From: Alistair Dodd [redacted]
Sent: 11 May 2017 16:48
To: Anita Gardner
Subject: RE: A/64/17/DOC 1-6 The Cottrells, Angmering

From: Ian Hayward [REDACTED]
Sent: 11 May 2017 10:01
To: Anita Gardner
Subject: RE: A/64/17/DOC 1-6 The Cottrells, Angmering

Subject to the above amendment I would be minded to accept that that plans and details provided pertaining to condition 5 of A/173/16/PL are now acceptable from a highways perspective.

Rev	Description	Date
Job Reference New House The Cottrells Angmering Client AM Homes Ltd		
Drawing Title Site Works Plan Drawing No AD962/03 Rev		
Date	Scale	Dwg Size
28.02.17	1:100	A3
	Plot Style	Drawn
	ADCgreycols	TDG
	Checked	AD

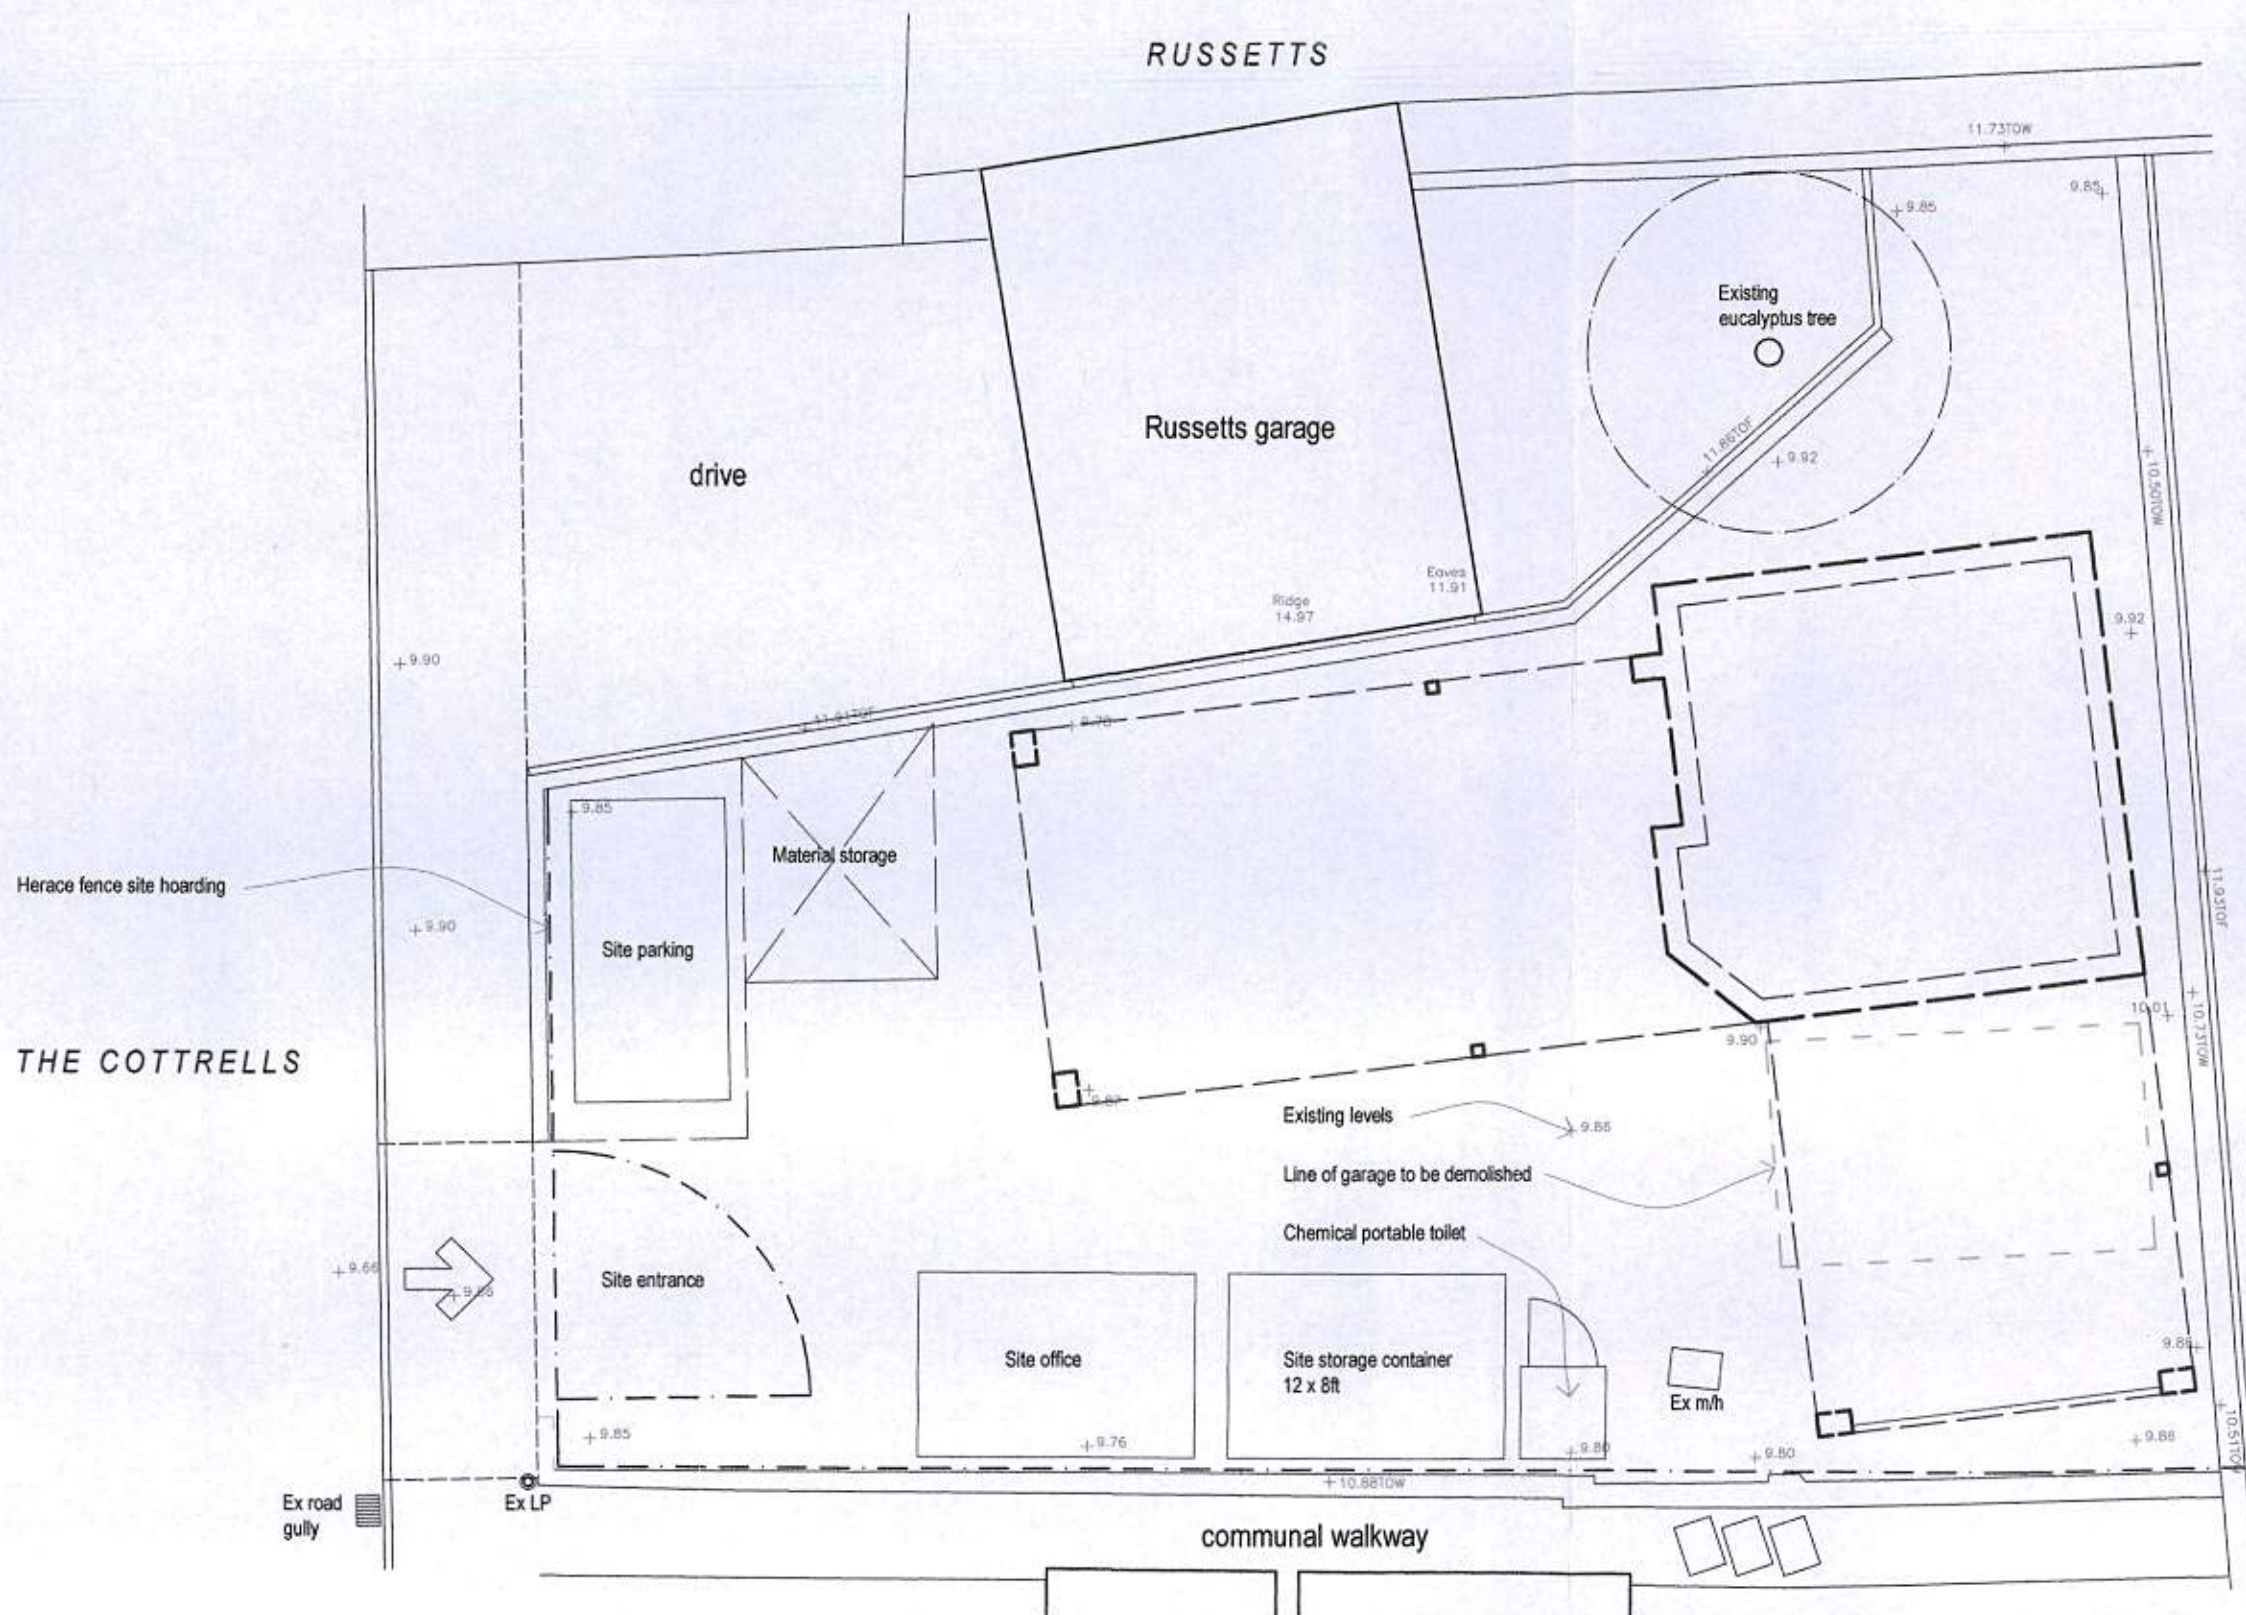
In response to the Highways query I confirm materials can only be delivery by small or medium sized vehicles due to the narrow site entrance into the Cottrells. As such we are able to accommodate such vehicles within the site area without blocking the cul-de-sac of the Cottrells.

Thank you for the email and please find attached our amended drawing No ADC 962/03A.

A		Flatbed delivery lorry added		04.05.17	
Rev		Description		Date	
Job Reference			Client		
New House The Cottrells Angmering			AM Homes Ltd		
Drawing Title			Drawing No		
Site Works Plan			AD962/03		
			Rev		
			A		
Date	Scale	Dwg Size	Plot Style	Drawn	Checked
28.02.17	1:100	A3	AD09xscale	TCG	AD

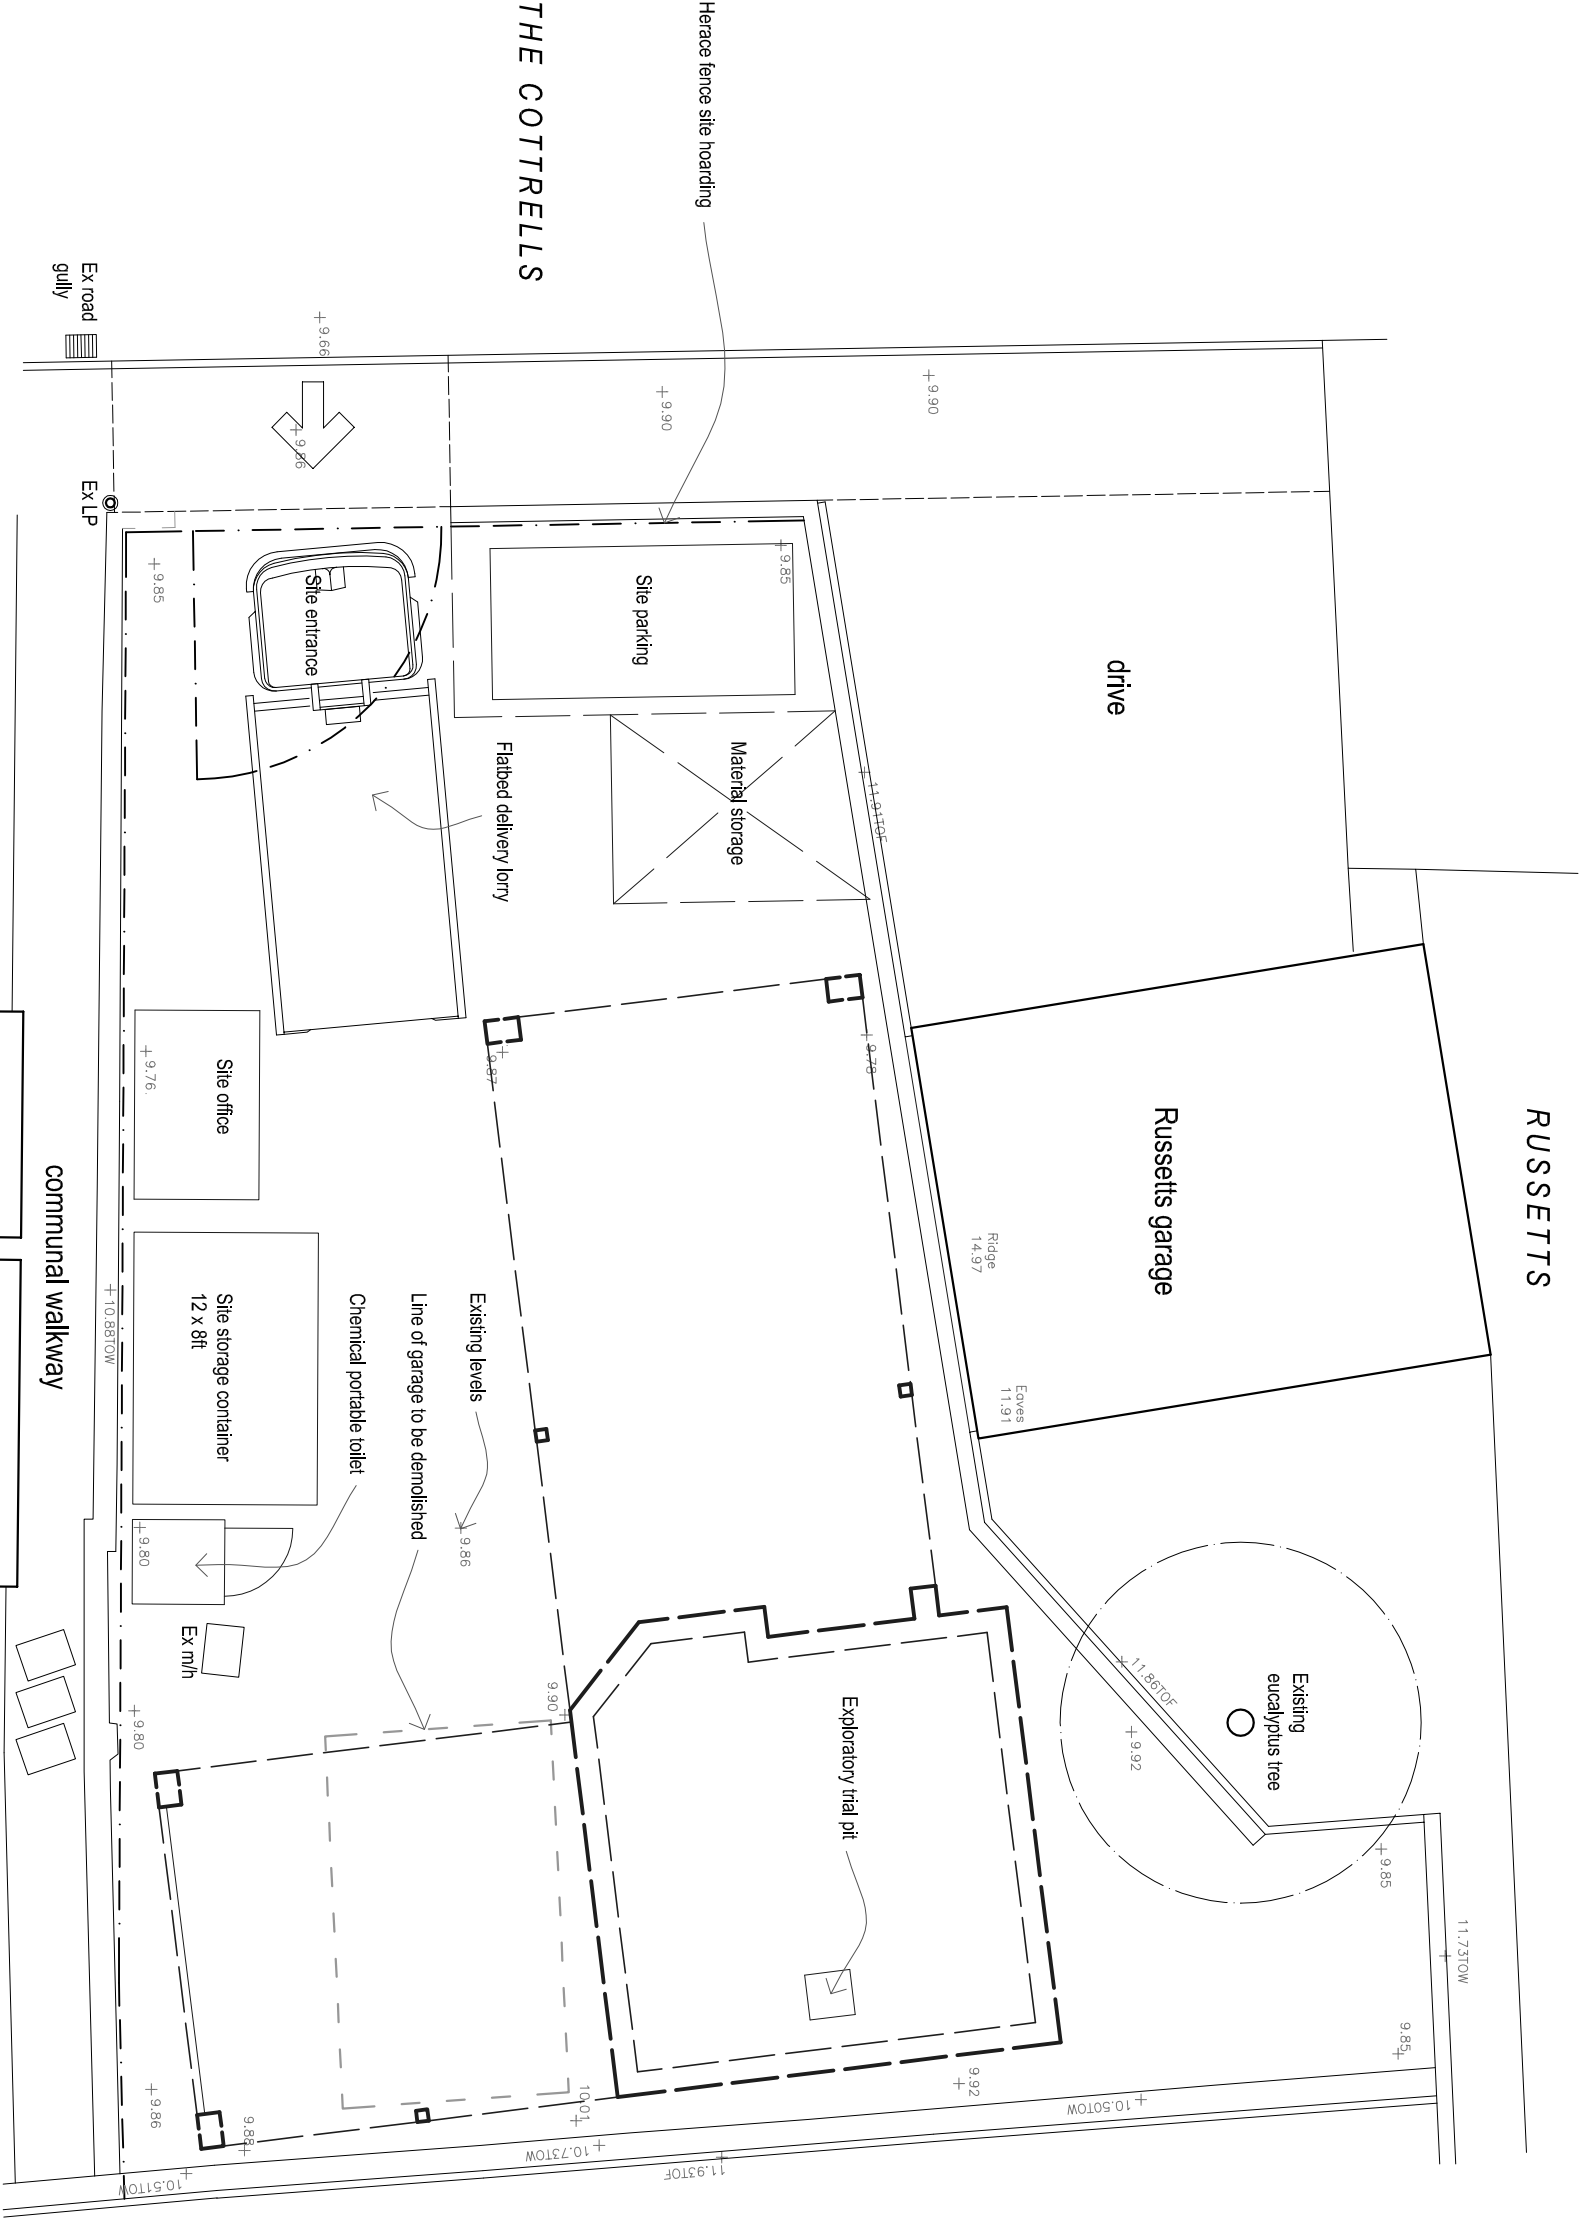
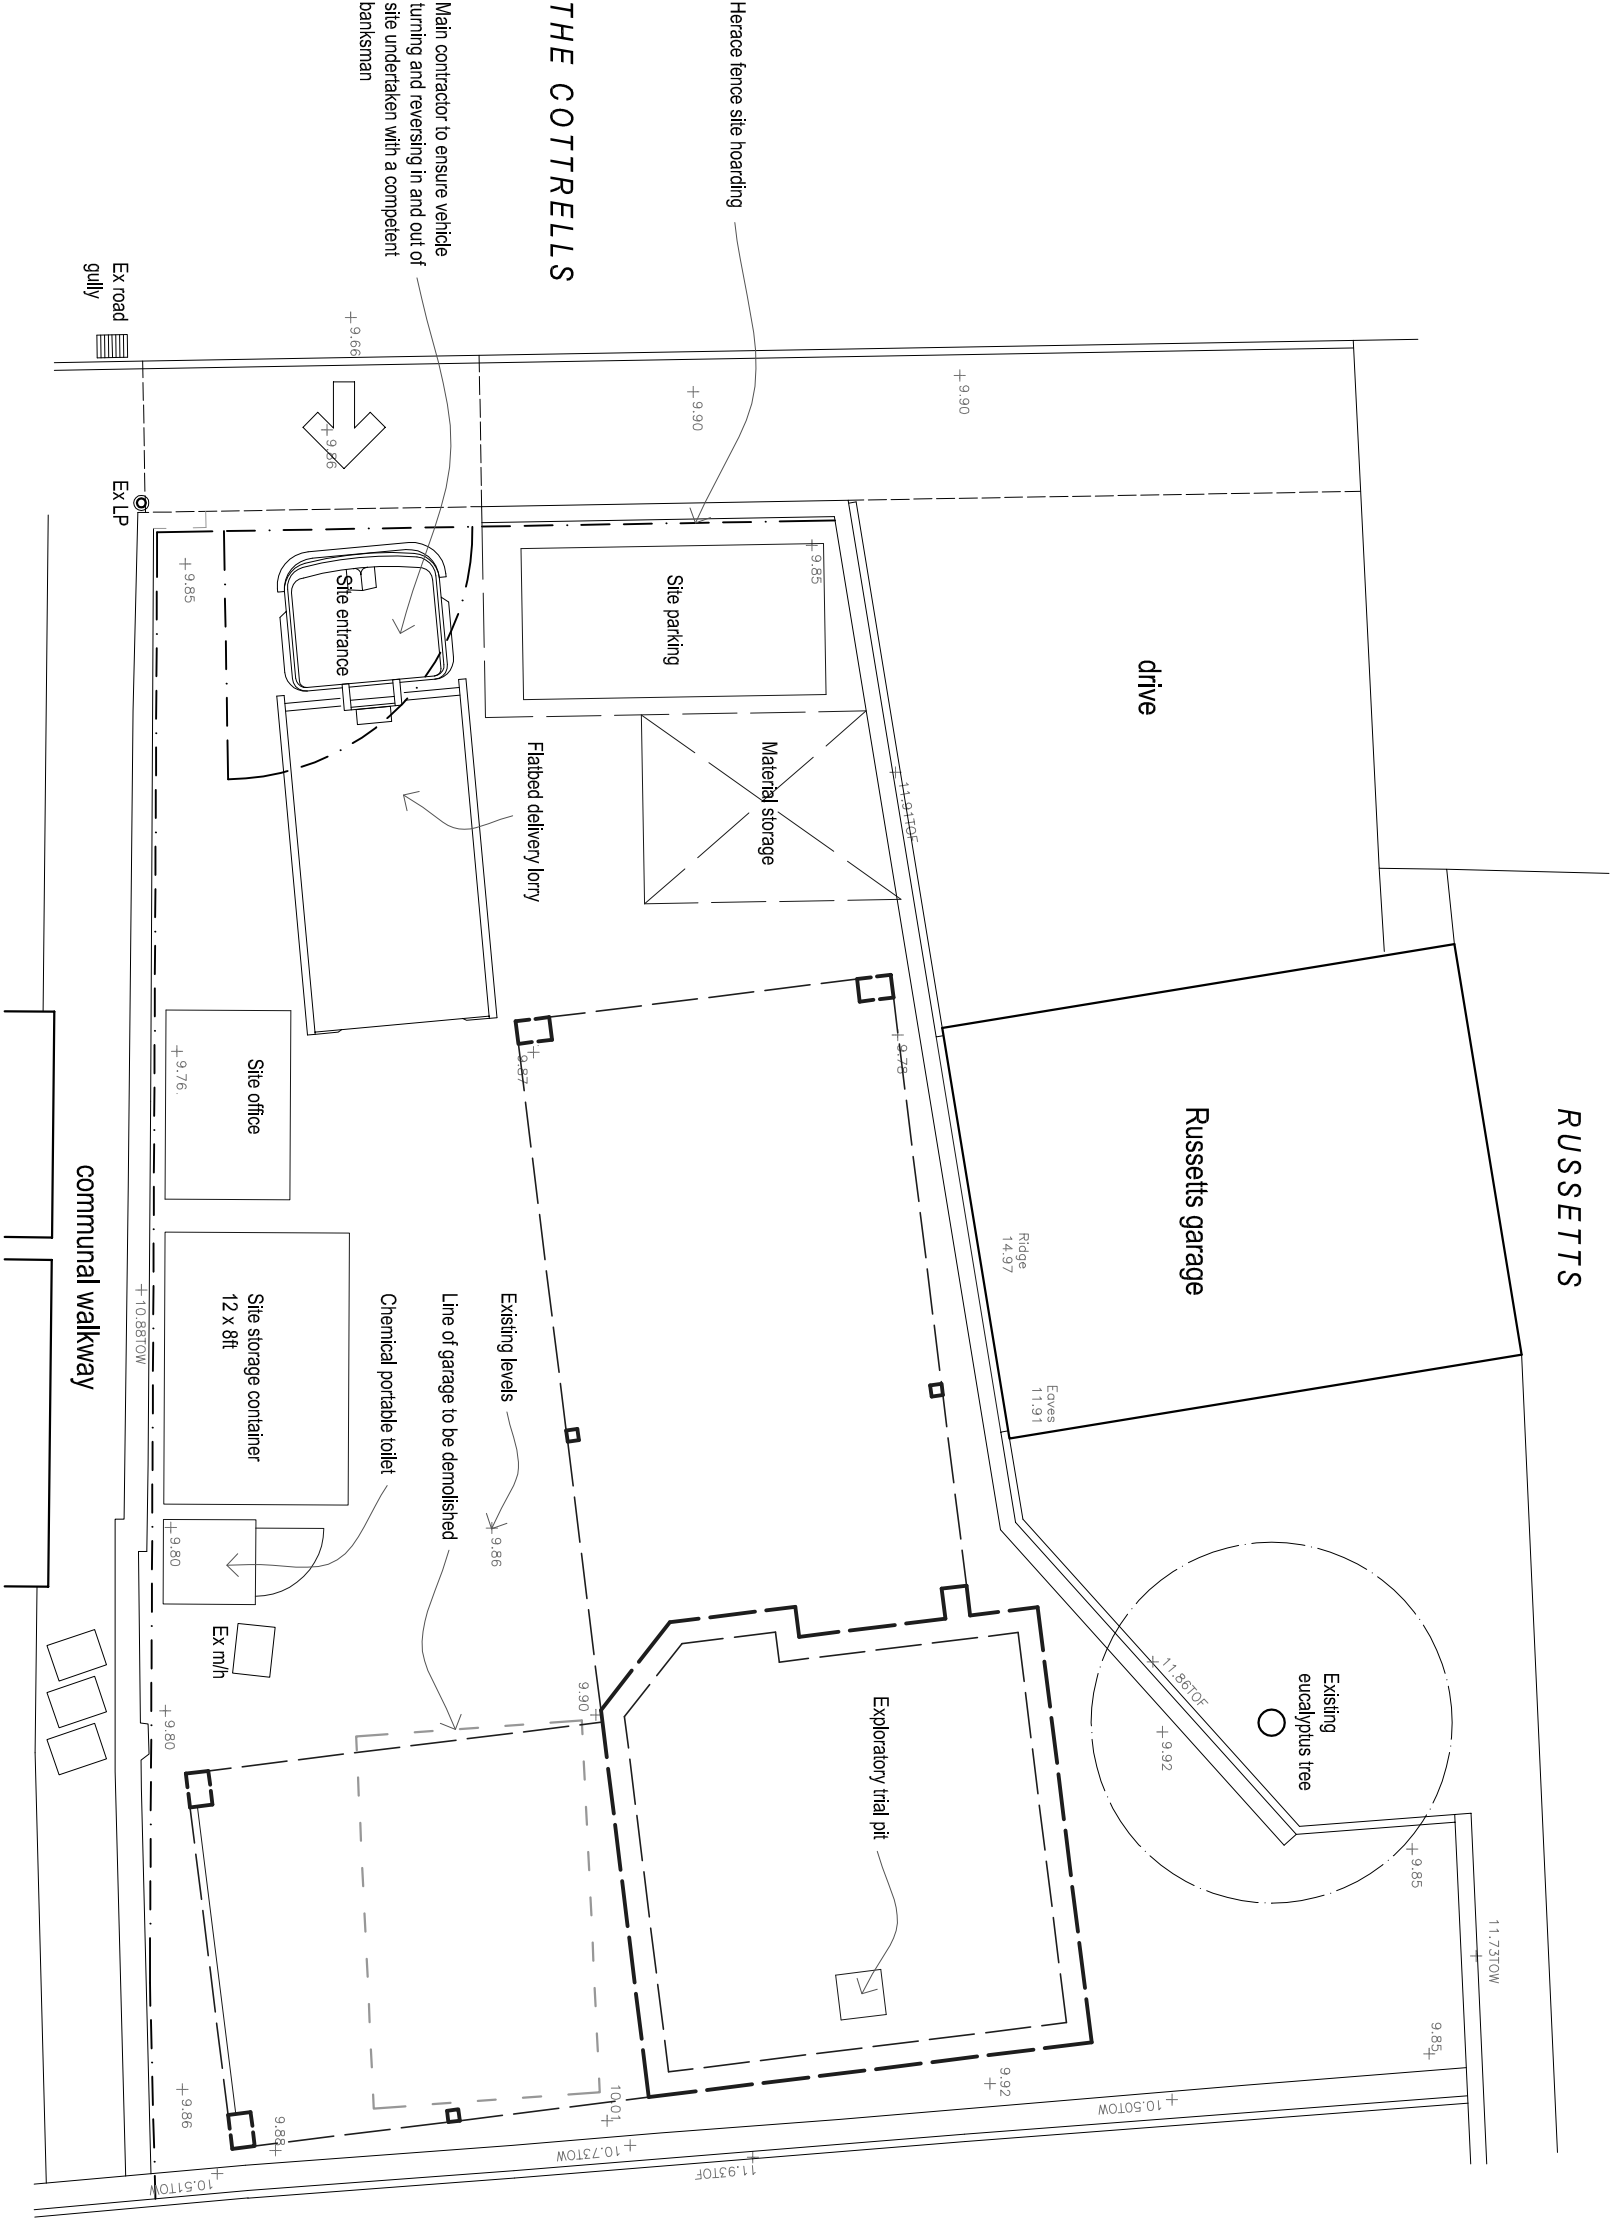
Thanks for this, based on the revised plan (AD962/03 A) the applicant has demonstrated how a flatbed delivery lorry could be facilitate on site. It is clear from this plan that such a delivery lorry would not be able to turn on site. I would therefore recommend an annotation on the plan detailing that any reversing movements into or out of the site by construction vehicles are undertaken with the use of a competent banksman.

It is appreciated that some deliveries may need to be undertaken from the roadside.

Thank you for the feedback and I attach drawing No ADC 962/03B with a note added to that effect.
